City of Albuquerque Stormwater Construction Site Inspection Report

ESC File No.	C18E086	Project Name:	Alameda Mixed-Use		
NPDES Id. No.	NMR1001U5	Location:	6100 Alameda NE		
11/15/2021	Owner	Contractor			
Operator	Green Jeans West, LLC.	Snyder Construction			
Contact name & title	Roy Solomon	Terminated			
e-mail	roy@roysolomon.org				
Contact Phone #	505-401-1000				
COA Inspector	James Hughes	Start/End Time:	11:30am		
Construction Phase:	Stabilization/inactive				
Type of Inspection:		Storm Event	Post Storm Event >0.25"	311/Complaint	Follow Up
Weather at time of inspection?		clear	Temperature: ~		58
Estimated date of last storm 0.25" or greater		5/31/2021

EROSION AND SEDIMENT CONTROL PLAN

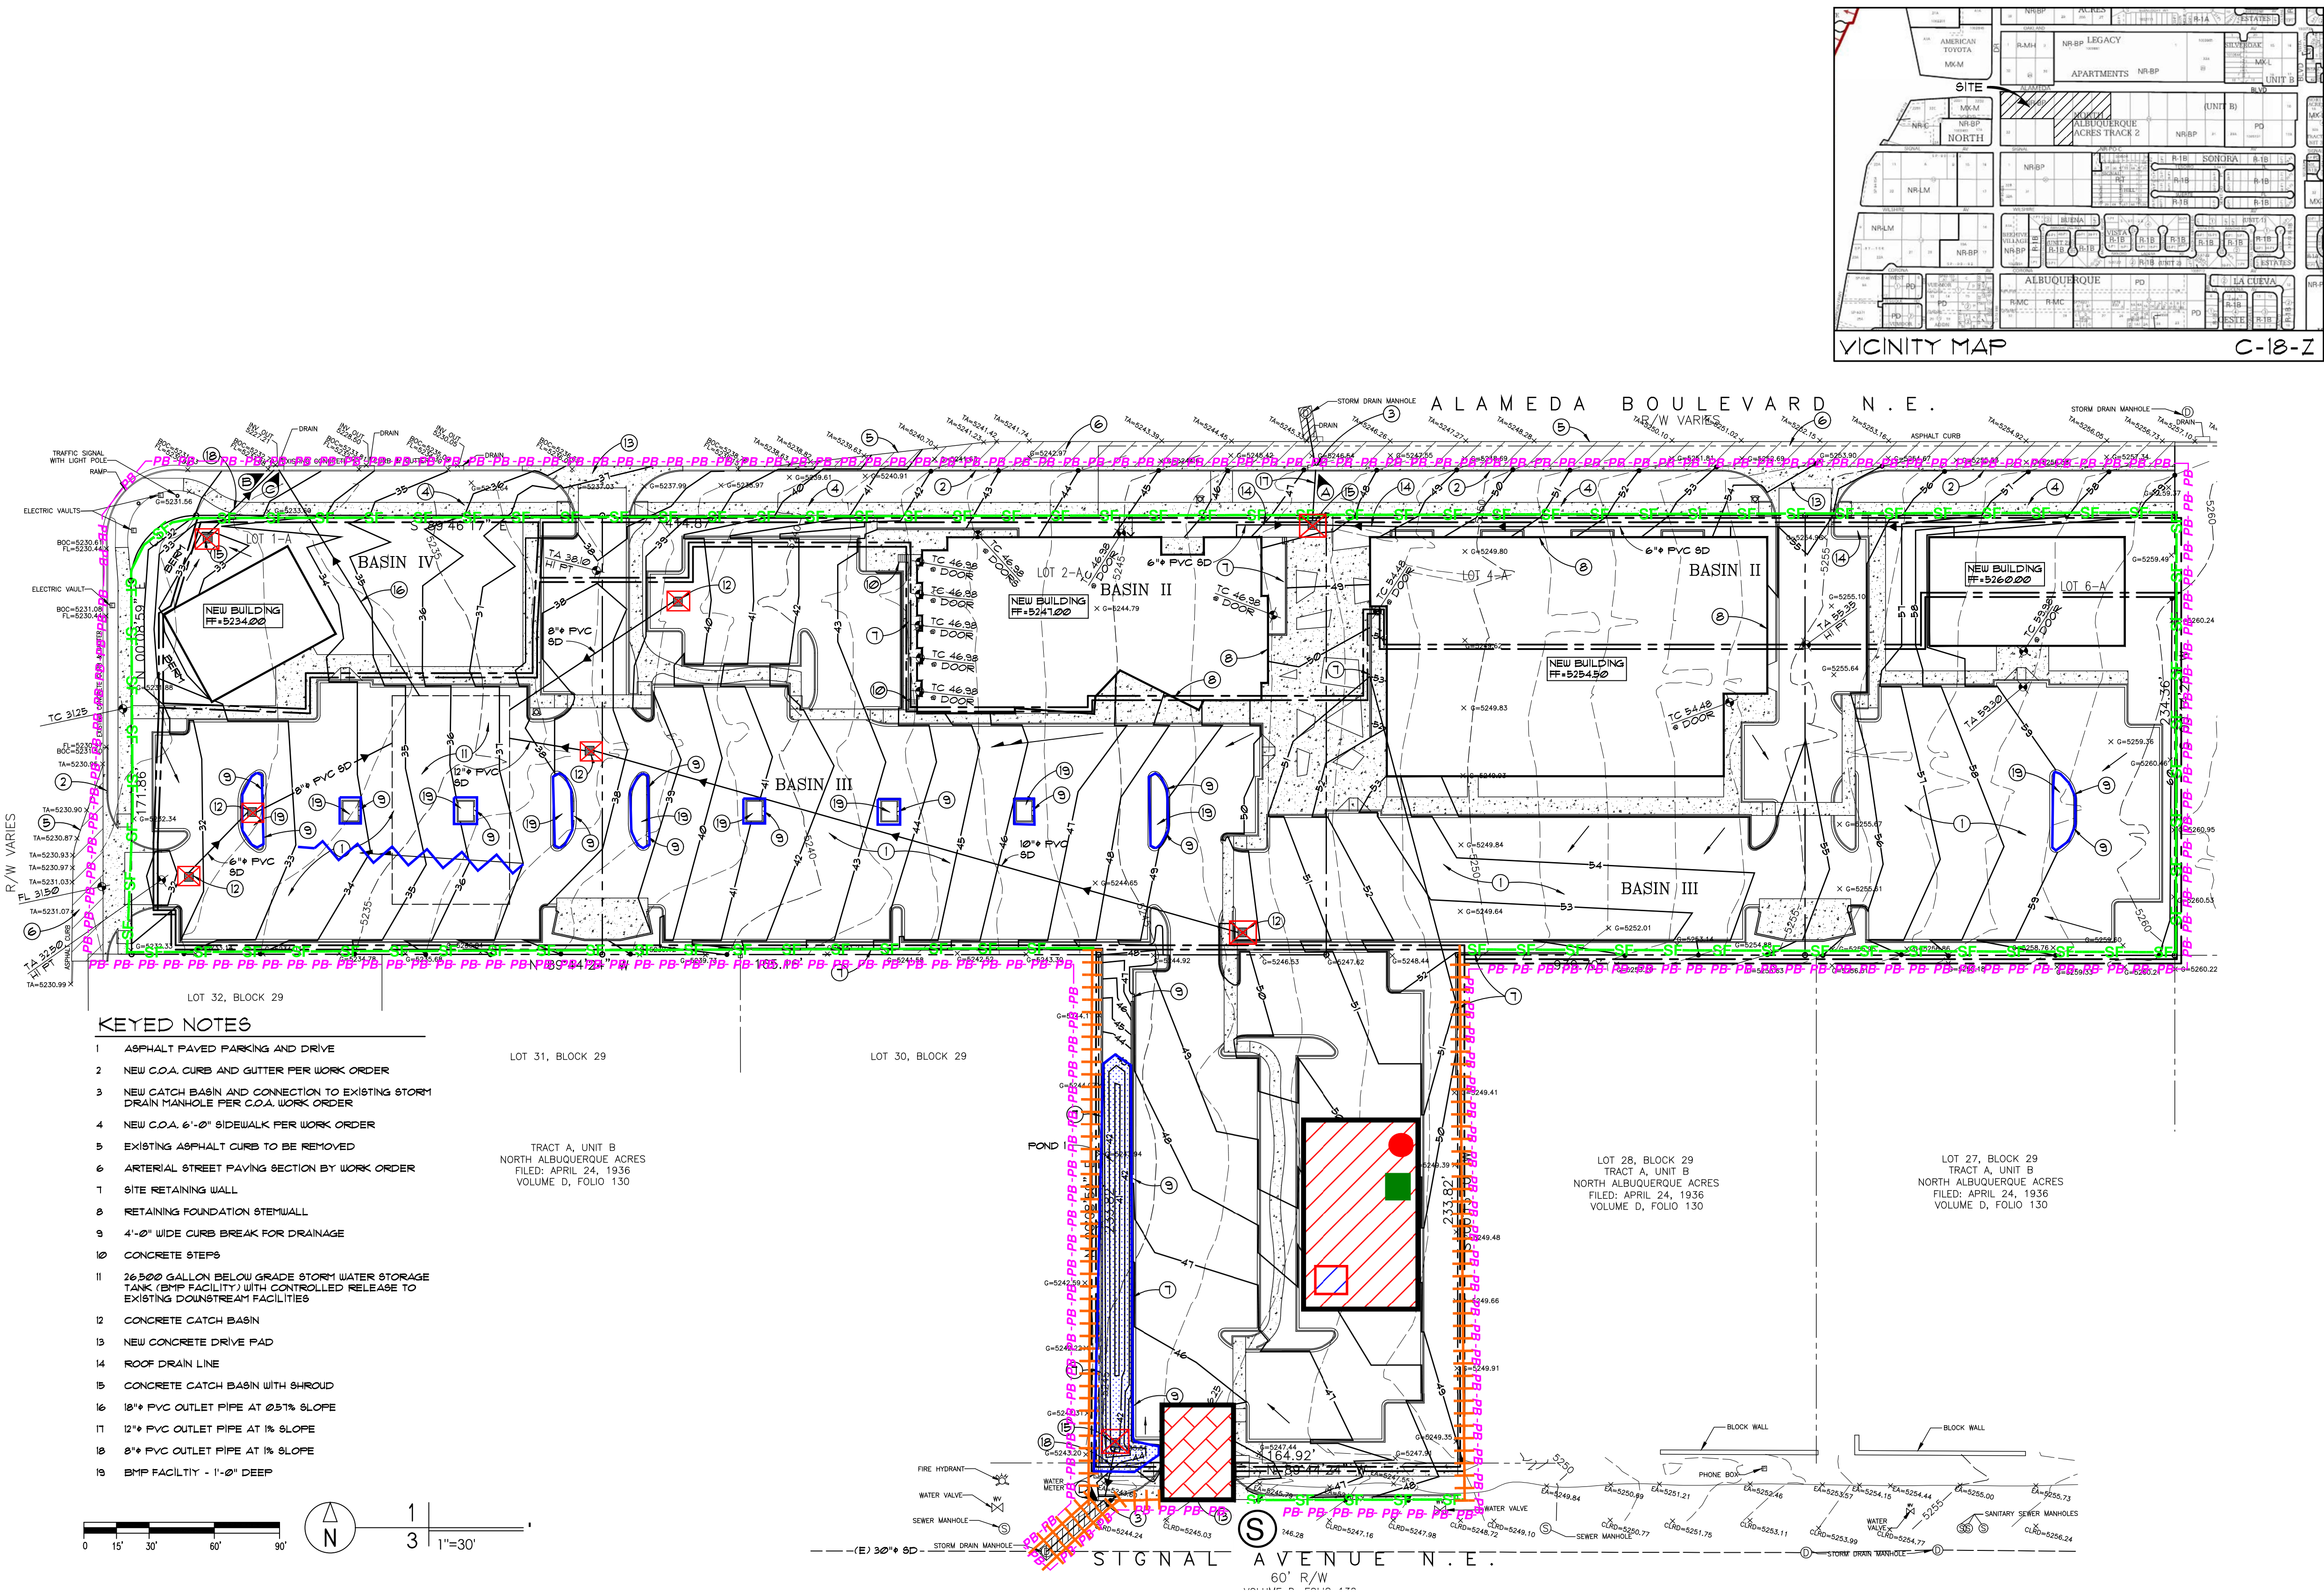
Item Number	Deficiency/ Corrective Action				
1	Repair/replace downed silt fence on both East ends of the property, or Spread gravel stabilization.				
2	SWPPP not up-to-date. Operator's signature missing from self-inspection reports. Operator didn't sign SWPPP. NOI missing from SWPPP (Tab 3 is empty).				
3	Posting still includes Snyder's permit coverage which has been terminated. Delete Snyder from the sign.				
4					
5
